21 December 2010

Re: Major Project MP08_0244 Environmental Assessment (EA) for Construction of a Mixed Use Commercial, Retail and Residential Development at 23-37 Lindfield Avenue and 11 Havilah Avenue, Lindfield

1 JUNE 21 -9AM
1:500

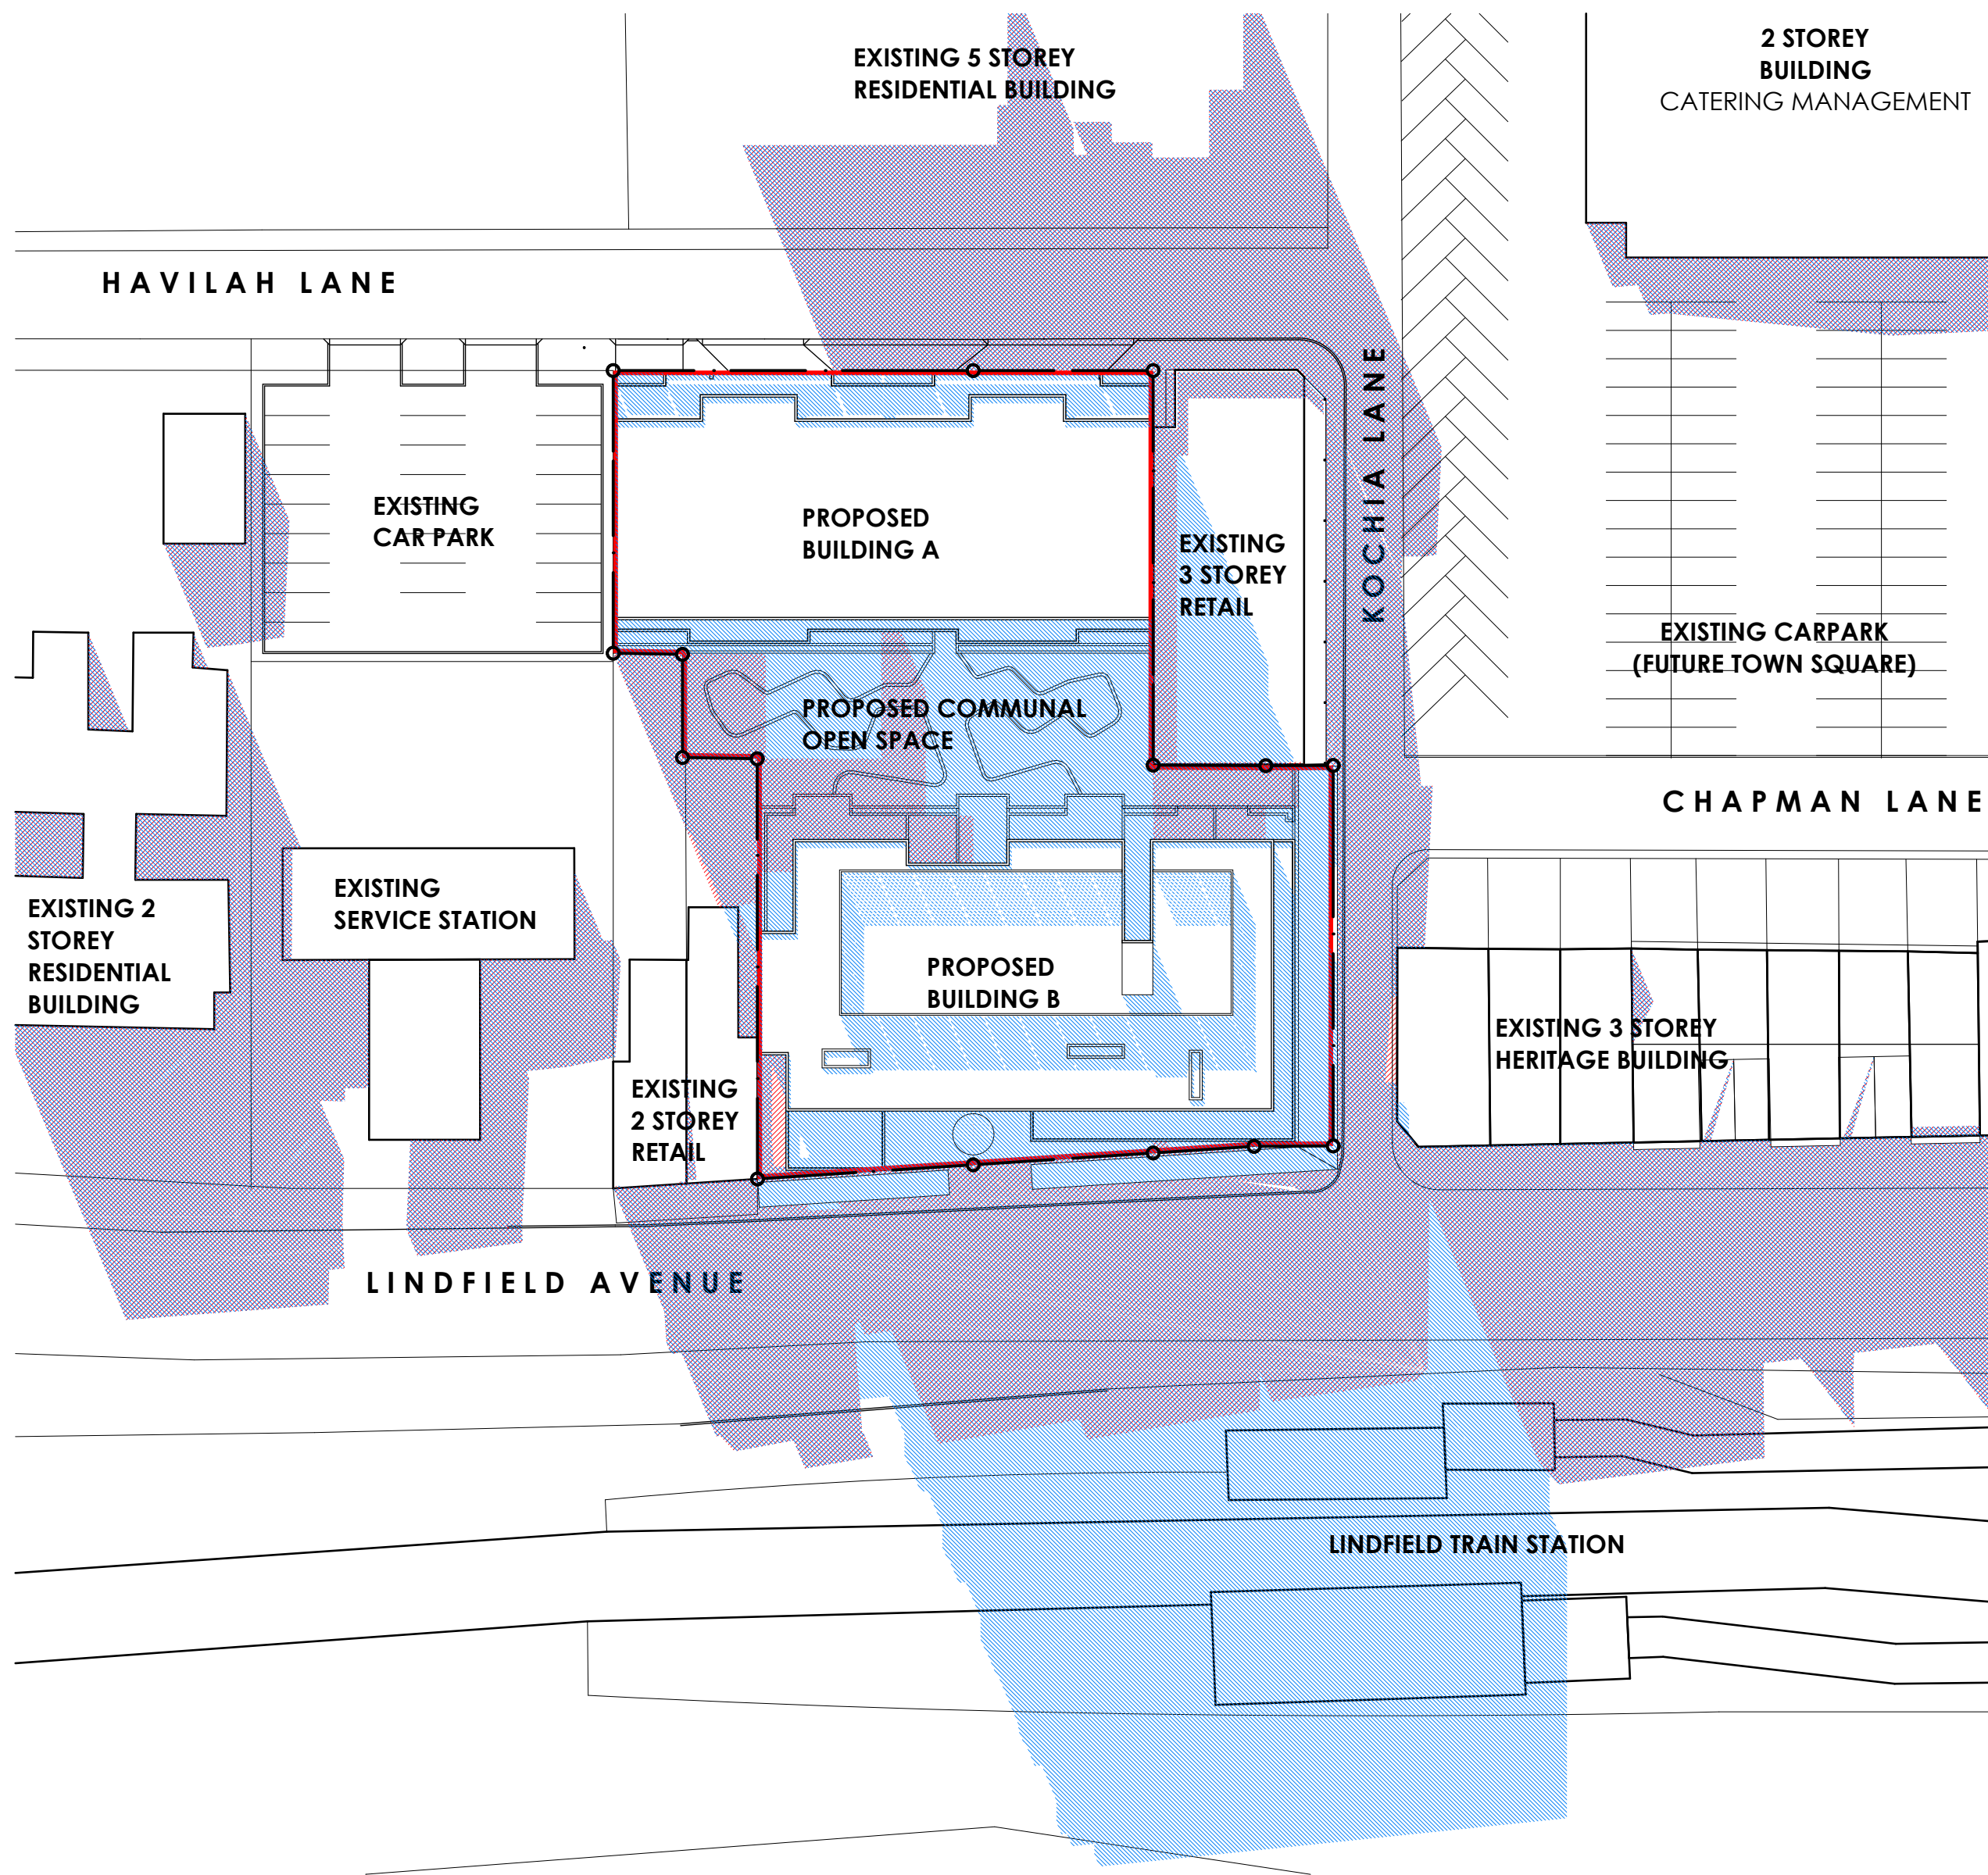
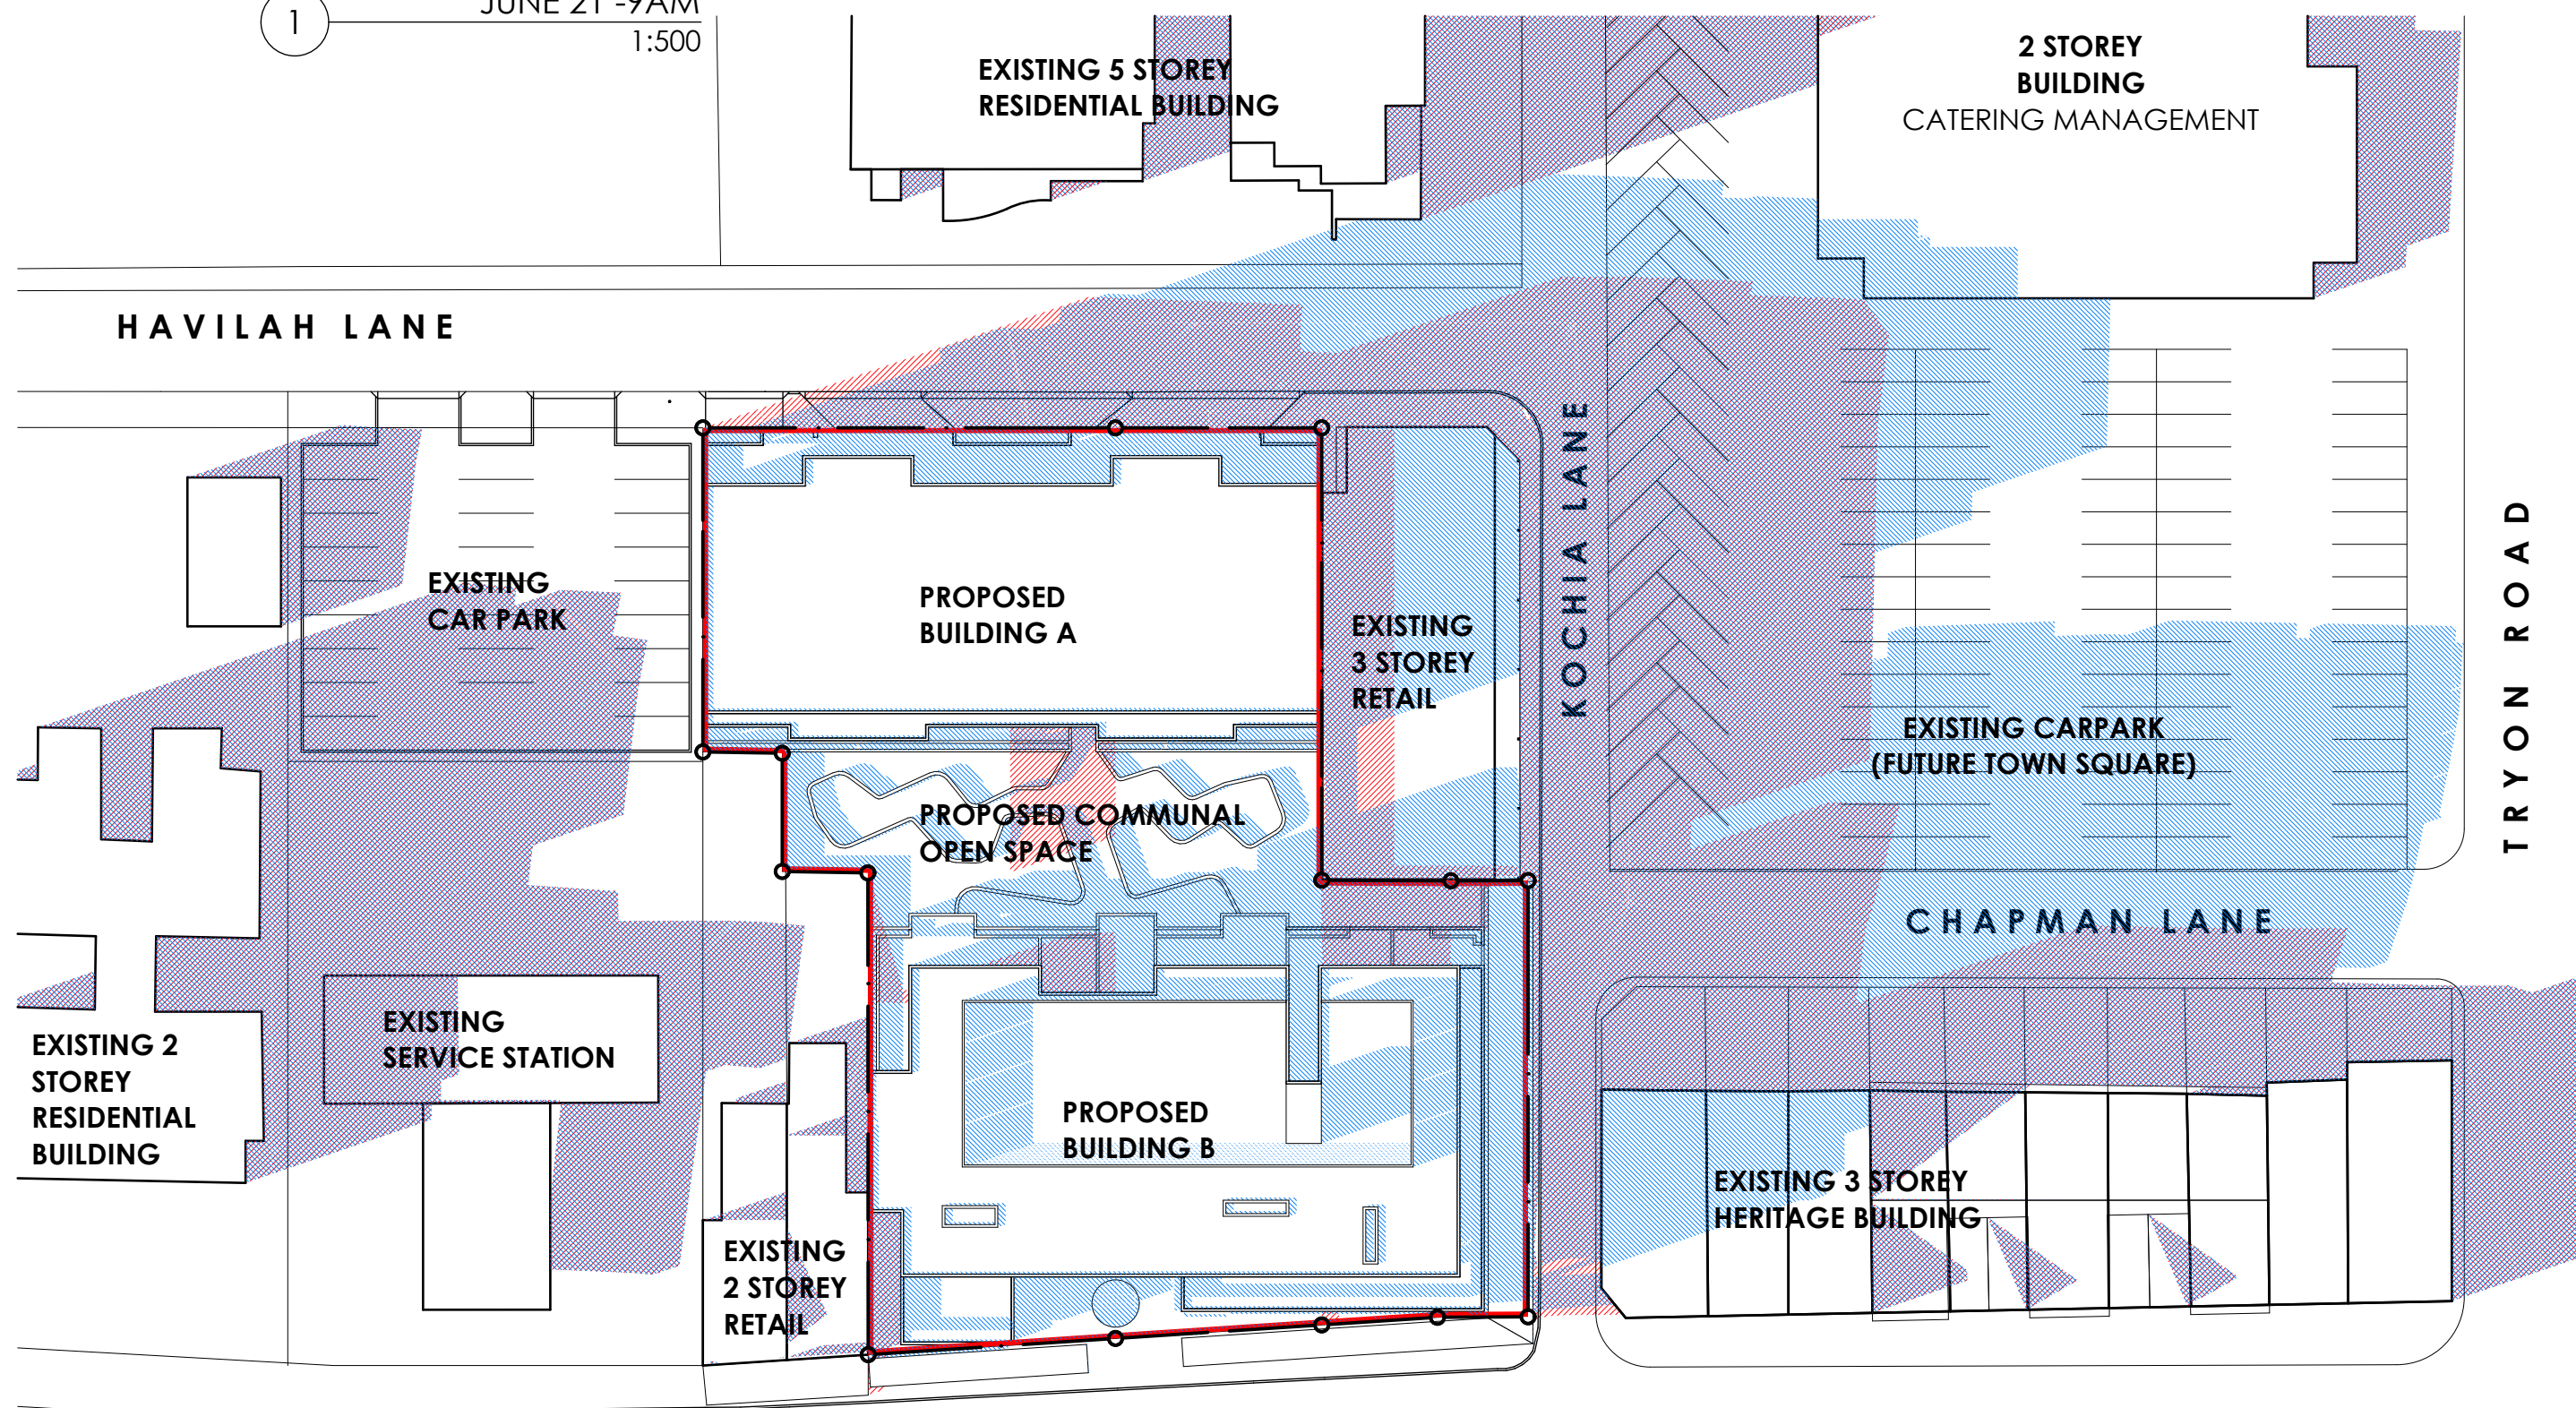
- The Lindfield Avenue building at 7 storeys will cast **significant shadow on the railway station (which is an open station)**, affecting a larger number of commuters as per the March, June and September Shadow Diagrams.

- **The development will cast significant shadows on future open space in the proposed town centre, causing loss of amenity to the broader community**, as per the June and September Shadow Diagrams.
